Application No: EP/58/11/

PLANNING APPLICATION REPORT

PROPOSAL: Replace 3 no. existing estate entrance gates (this application also falls within the parish Rustington)

Hobdens Property Management Ltd	
Project:-	The Willowhayne
Road Name:-	The Ridings
Drawn By:-	Michael Cornwell
Scale:-	1:50
Date:-	31/05/2011
Drawing No. 2

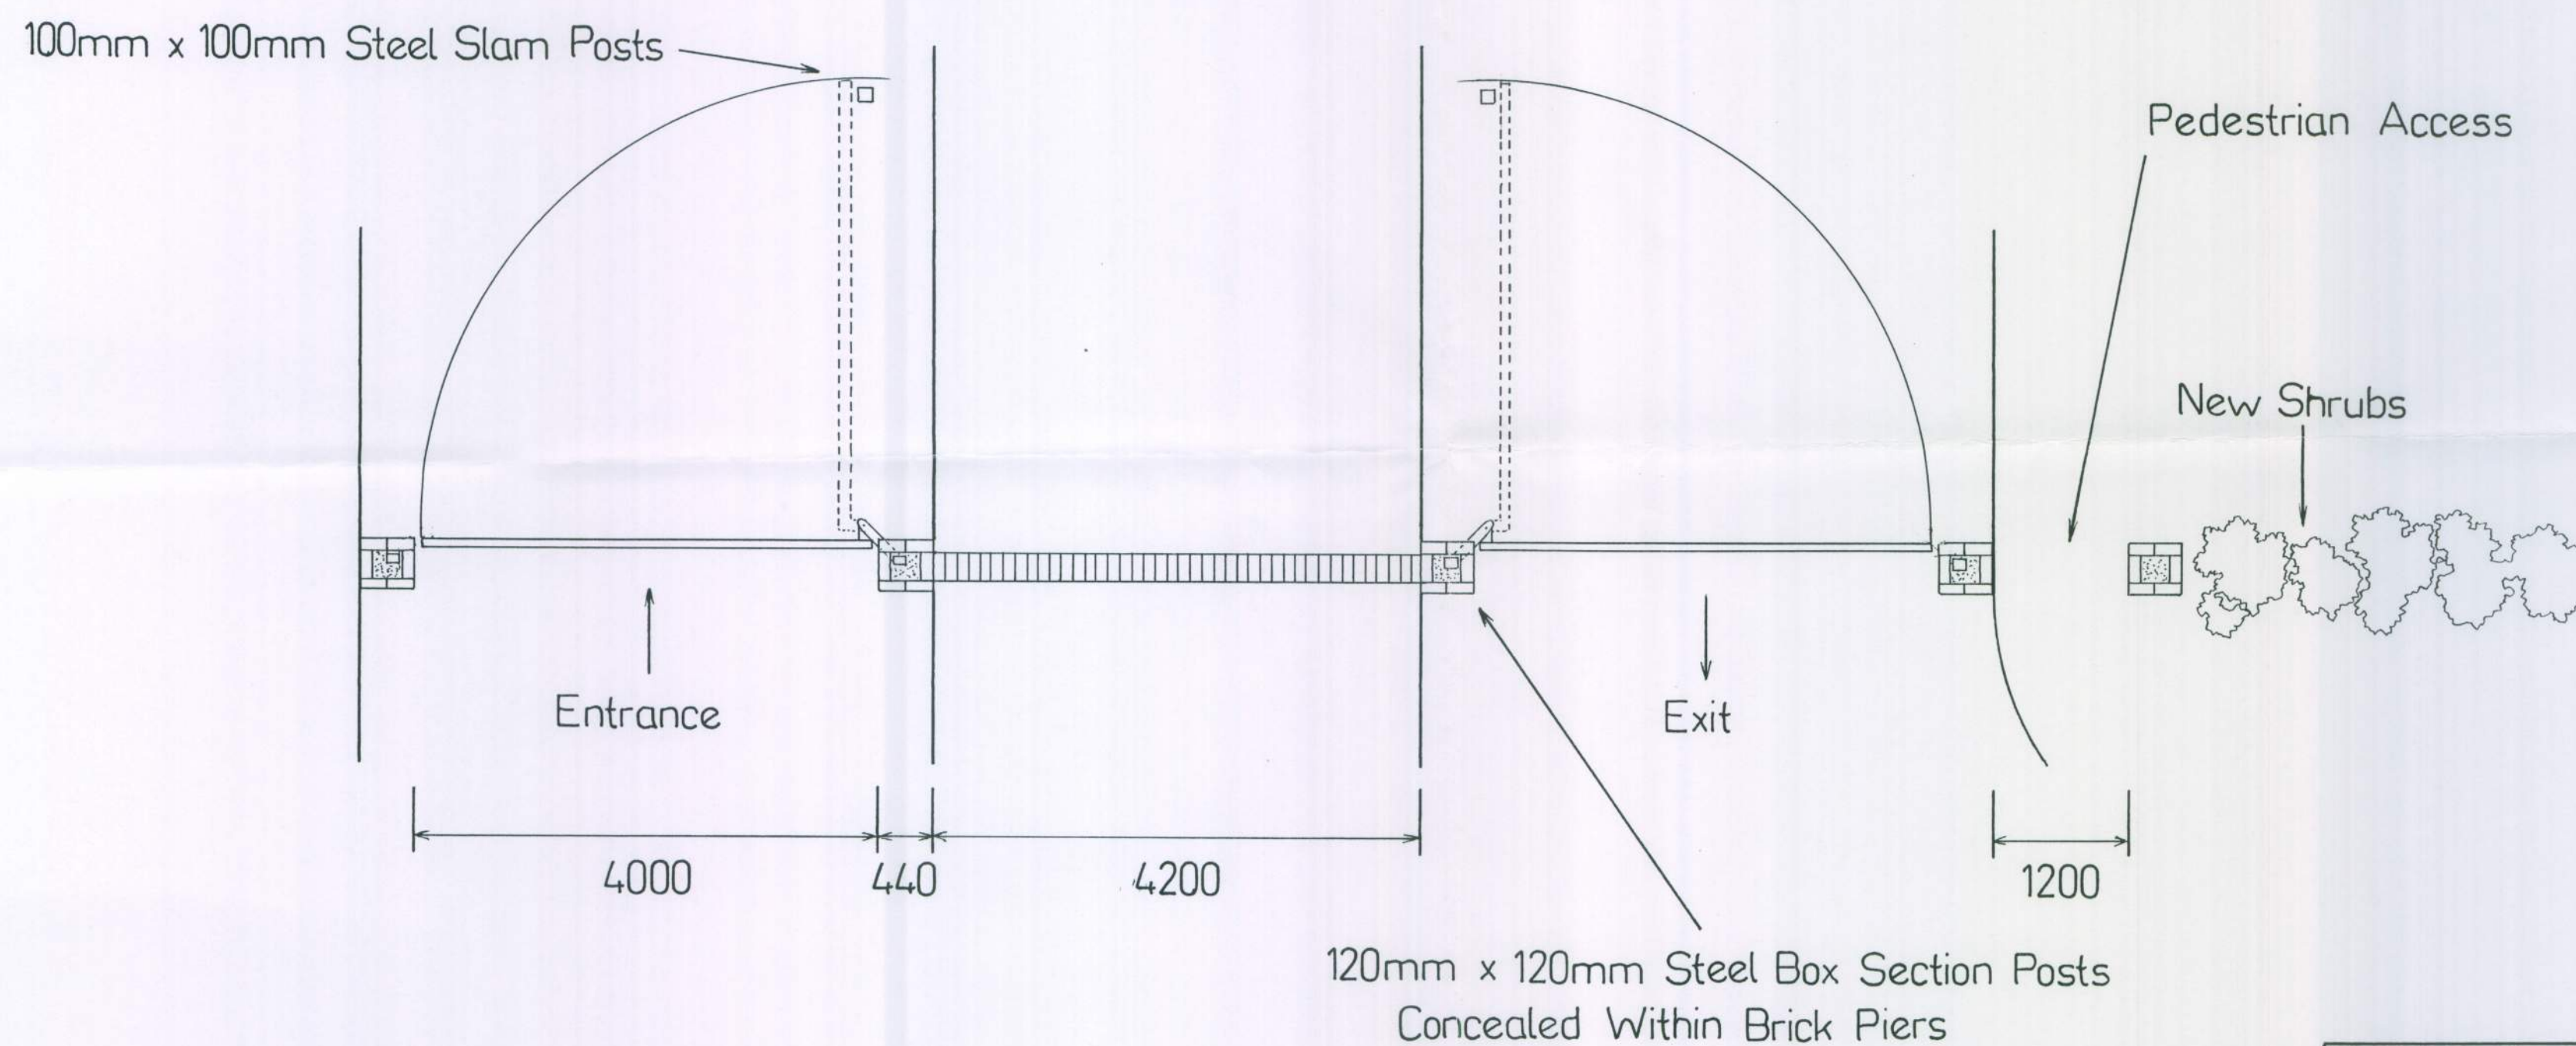
- 1 Given their height, design and extent the proposed gates, walling and piers at the entrances specifically to Angmering Lane and The Ridings would constitute an alien feature and significant closure of the open vista in the locality which would be out of keeping with the open, landscaped appearance of the estate and would be detrimental to the visual amenities of the locality in conflict with policy GEN7 of the Arun District Local Plan.

Hobdens Property Management Ltd		
Project:-	The Willowhayne	
Road Name:-	Angmering Lane	
Drawn By:-	Michael Cornwell	
Scale:-	1:50	Drawing No. 1
Date:-	31/05/2011

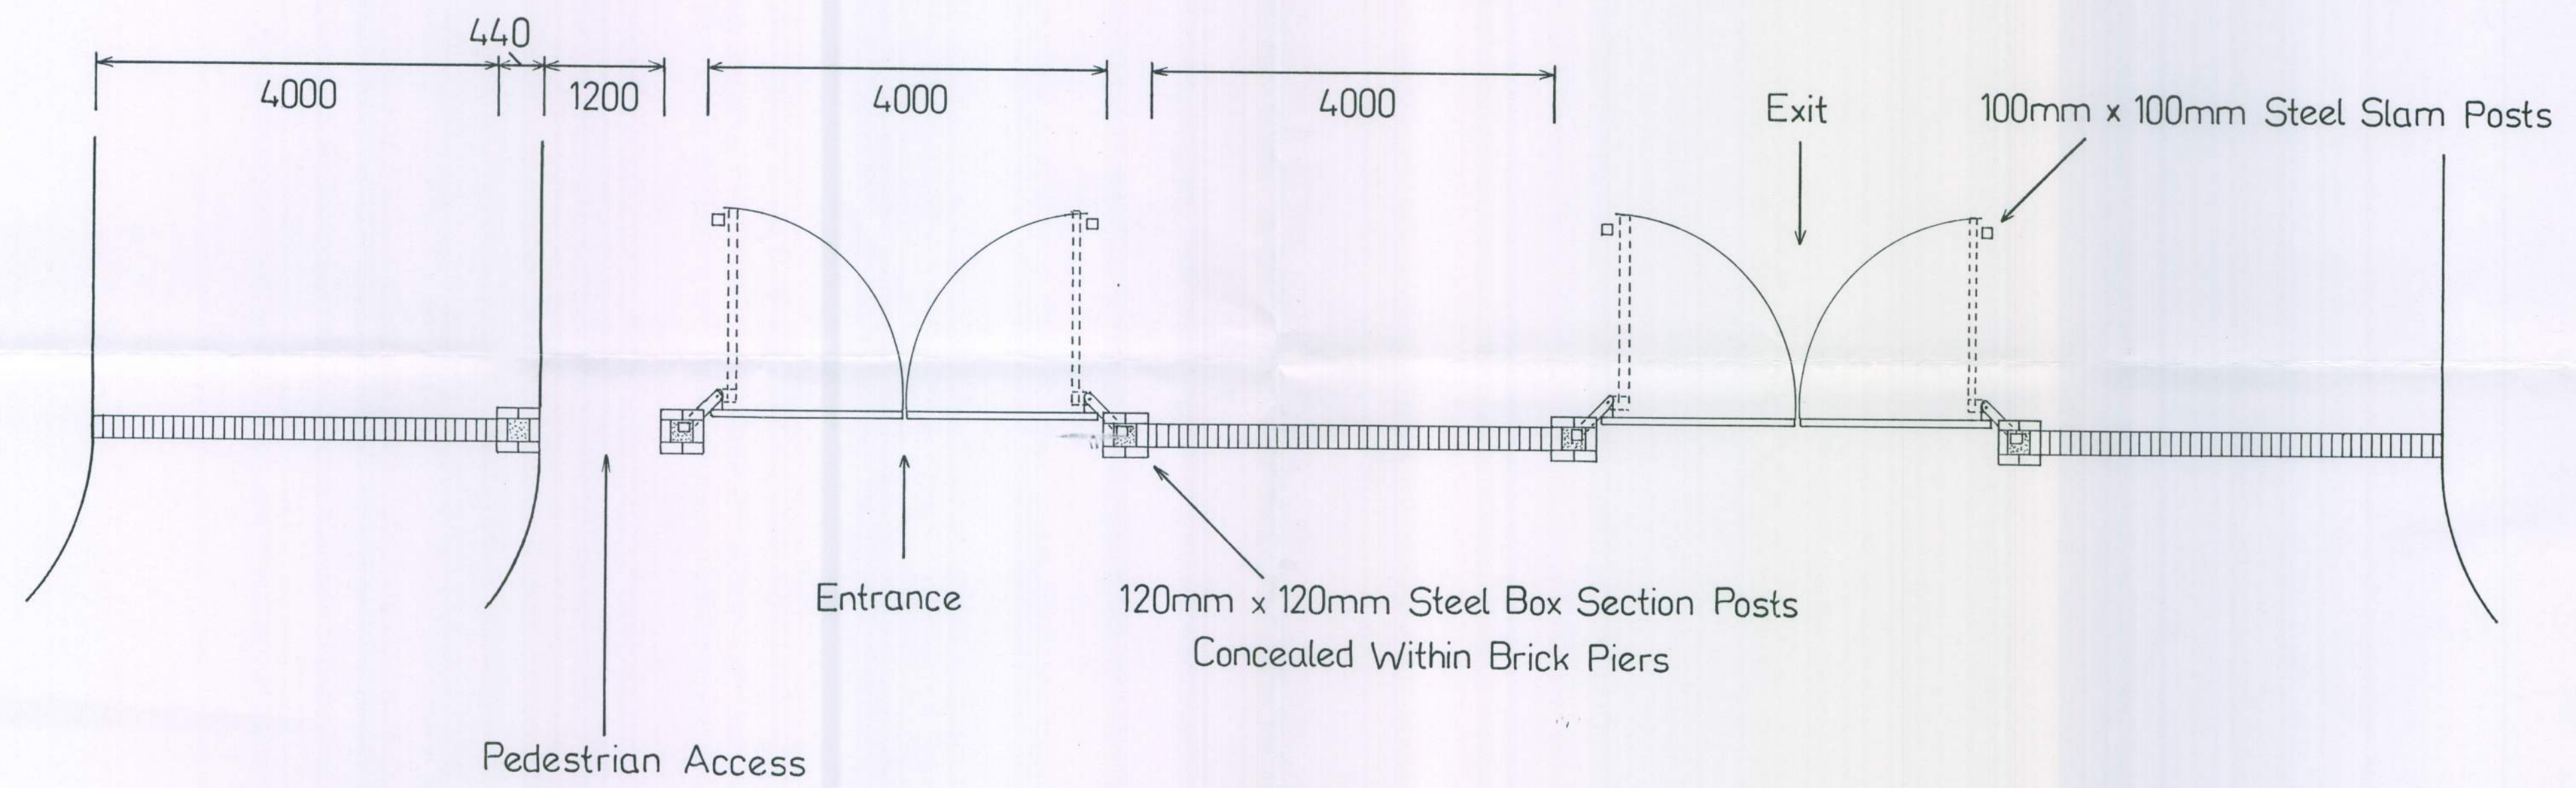
Proposed gates particularly at north end of Angmering Lane have a rural simplicity which suits this leafy corner as the main road passes the parish church. The proposed design is pretentious and overblown and suburban and would be destructive of the general view which is a Conservation Area incorporating Grade I Listed St Mary's Church and thatched cottage.

The design of the existing barriers is such that their impact on the locality is minimal. Whereas the proposed wall and gates are much more suburban in nature and would clearly define the boundary between the estate and the road network. Consequently, it is considered that the proposal would form a feature that would conflict with its locality.

- 2 The site at the junction of Angmering Lane lies within an area designated as a Conservation Area under Section 69, 70 and 72 of the Planning (Listed Buildings and Conservation Areas) Act 1990 and the proposed estate entrance gates by reason of their design, height and extent would conflict with the Local Planning Authority's intention to protect and enhance the visual amenities and environment of such areas, and with policies GEN7 and AREA2 of the Arun District Local Plan policy BE6 of the South East Plan and Planning Policy Statement 5 Planning for the Historic Environment.
